Our ref: F2006/00118 (D03874958)

**RE: SSD-9691 ORICA SOUTHLANDS WAREHOUSE ESTATE**

Thank you for the opportunity to comment on State Significant development (SSD) application for a warehouse and distribution facility at 28 McPherson Street, Banksmeadow in the Bayside Local Government Area (LGA).

Drawing : **PODIUM SLAB PLAN - STAGE 1**

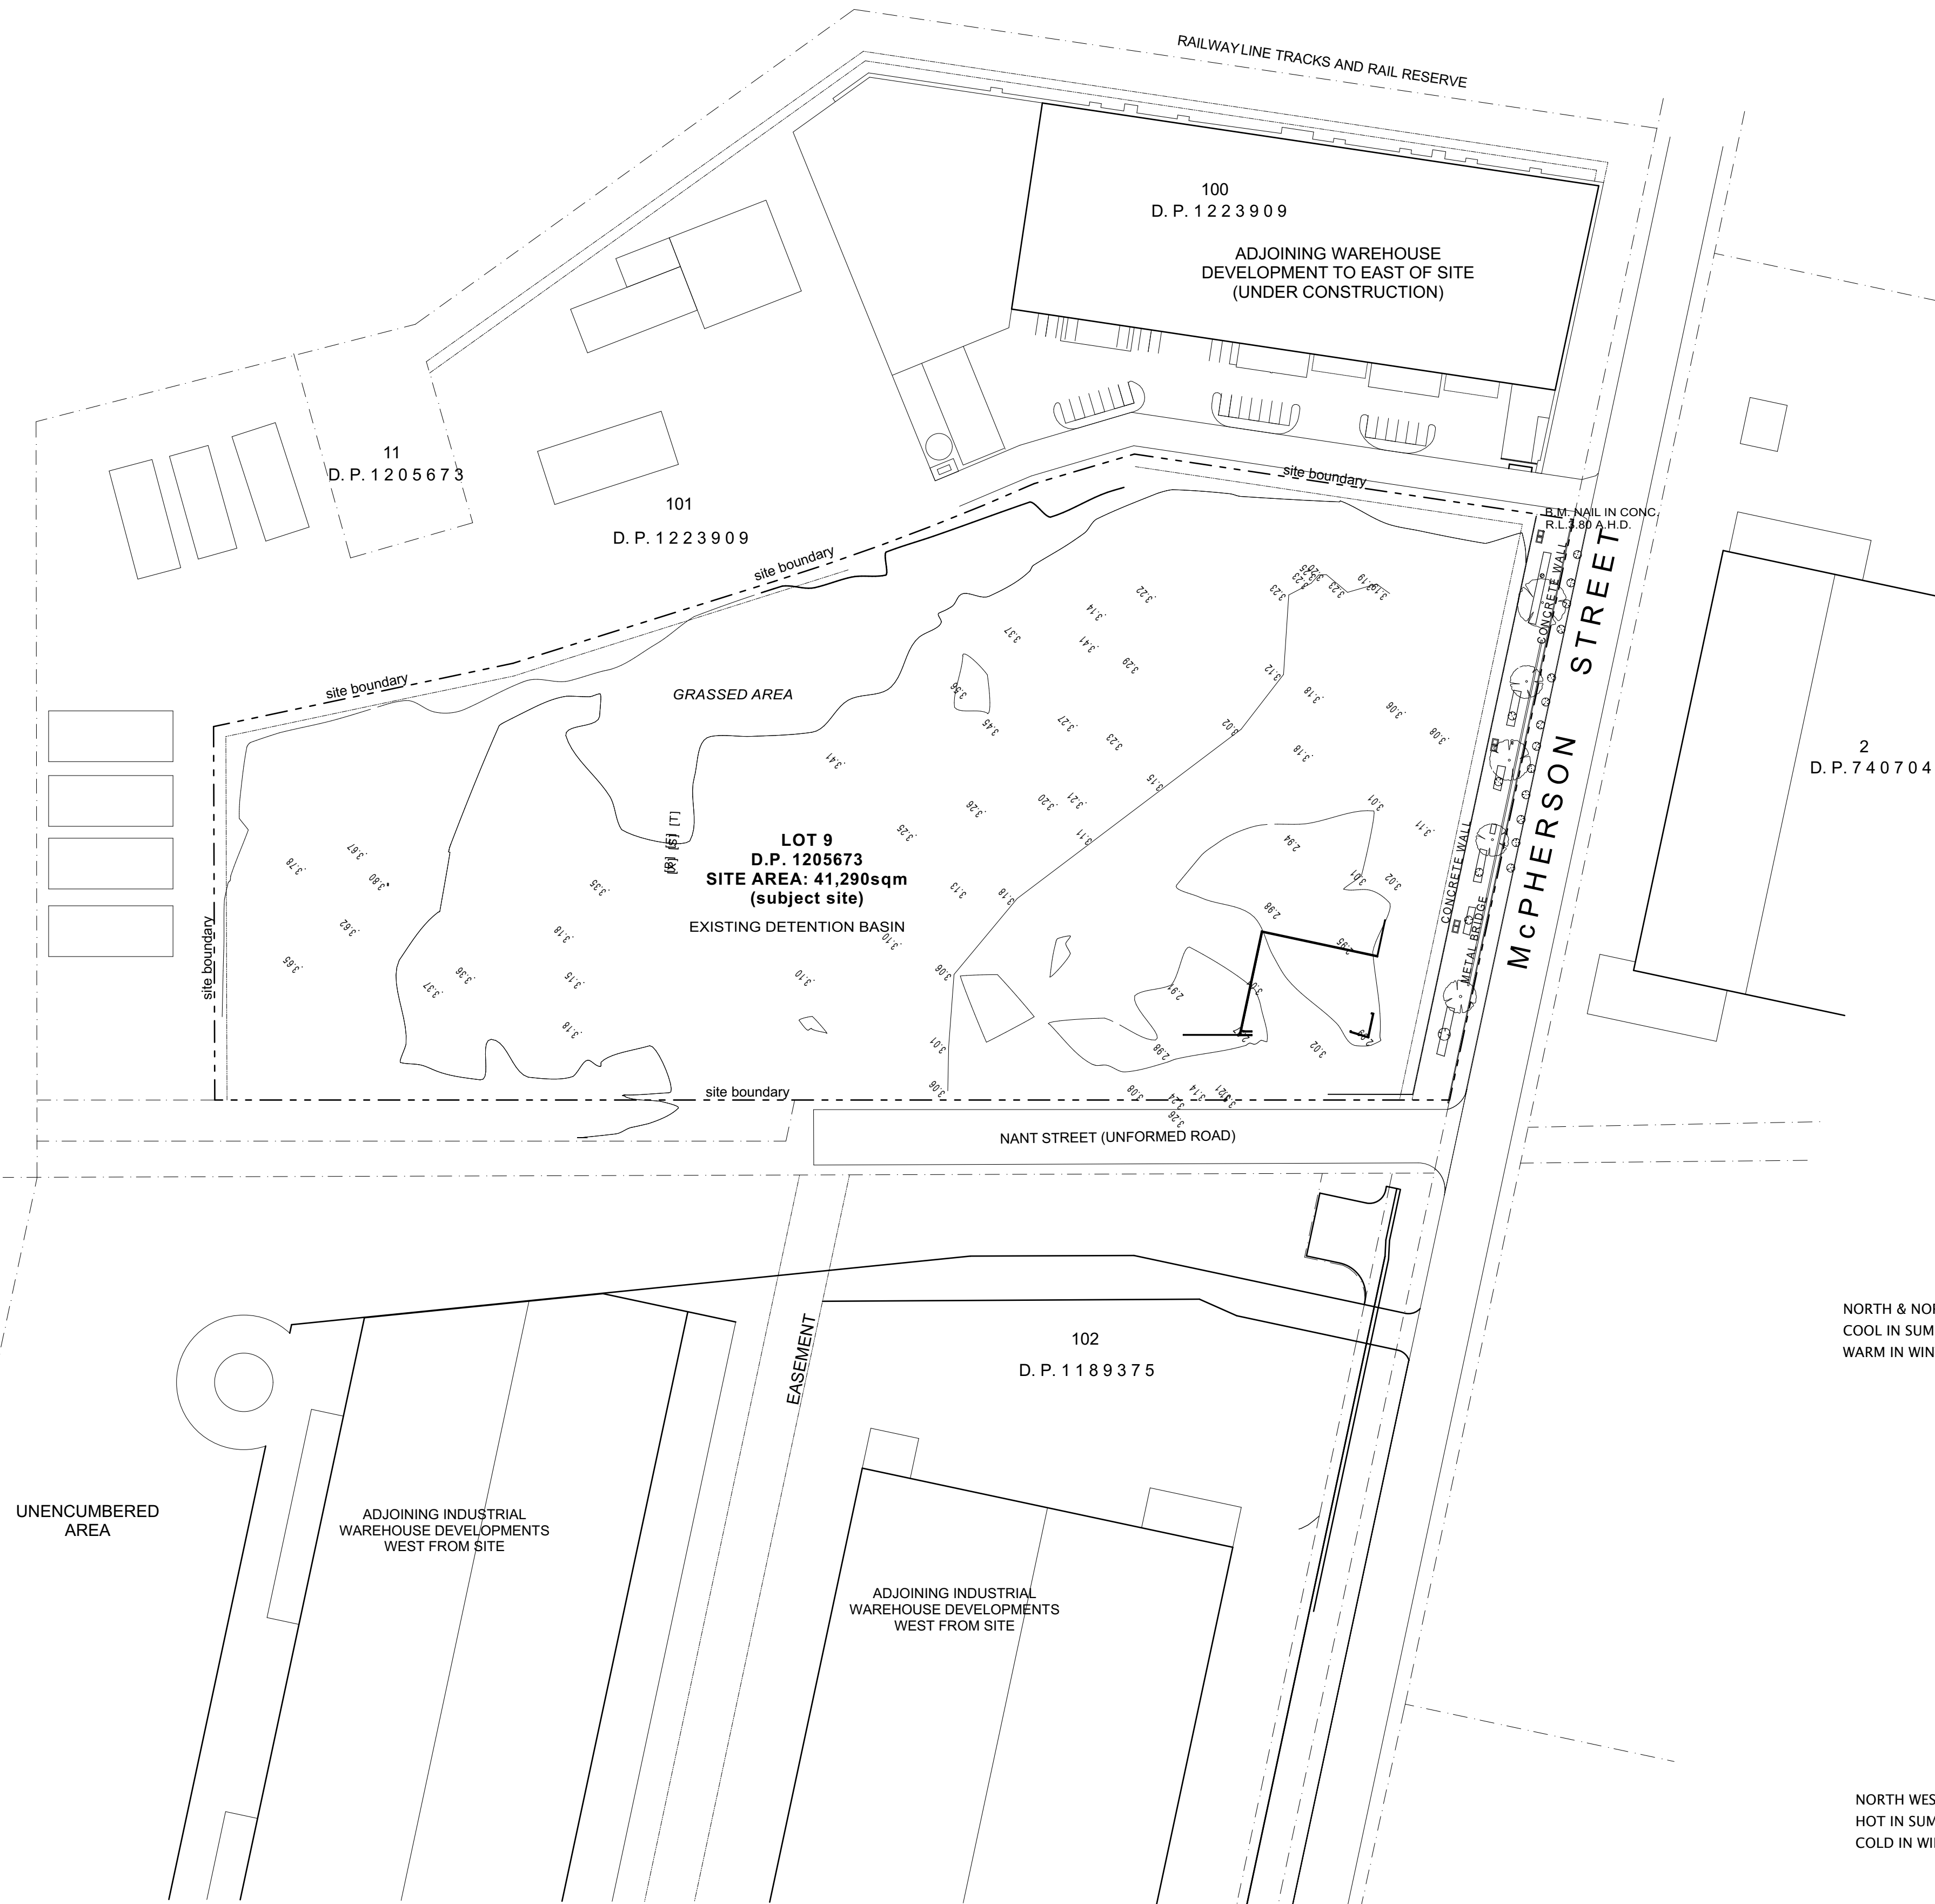
In particular, from reviewing the proposed plans of the development, the ramps to the raised concrete platform and the piles supporting the platform will be at grade. Council is concerned at the flooding implications of these at grade structures which would reduce the storage capacity of the flood detention basin and may also have an impact on the predicted flow of floodwaters.
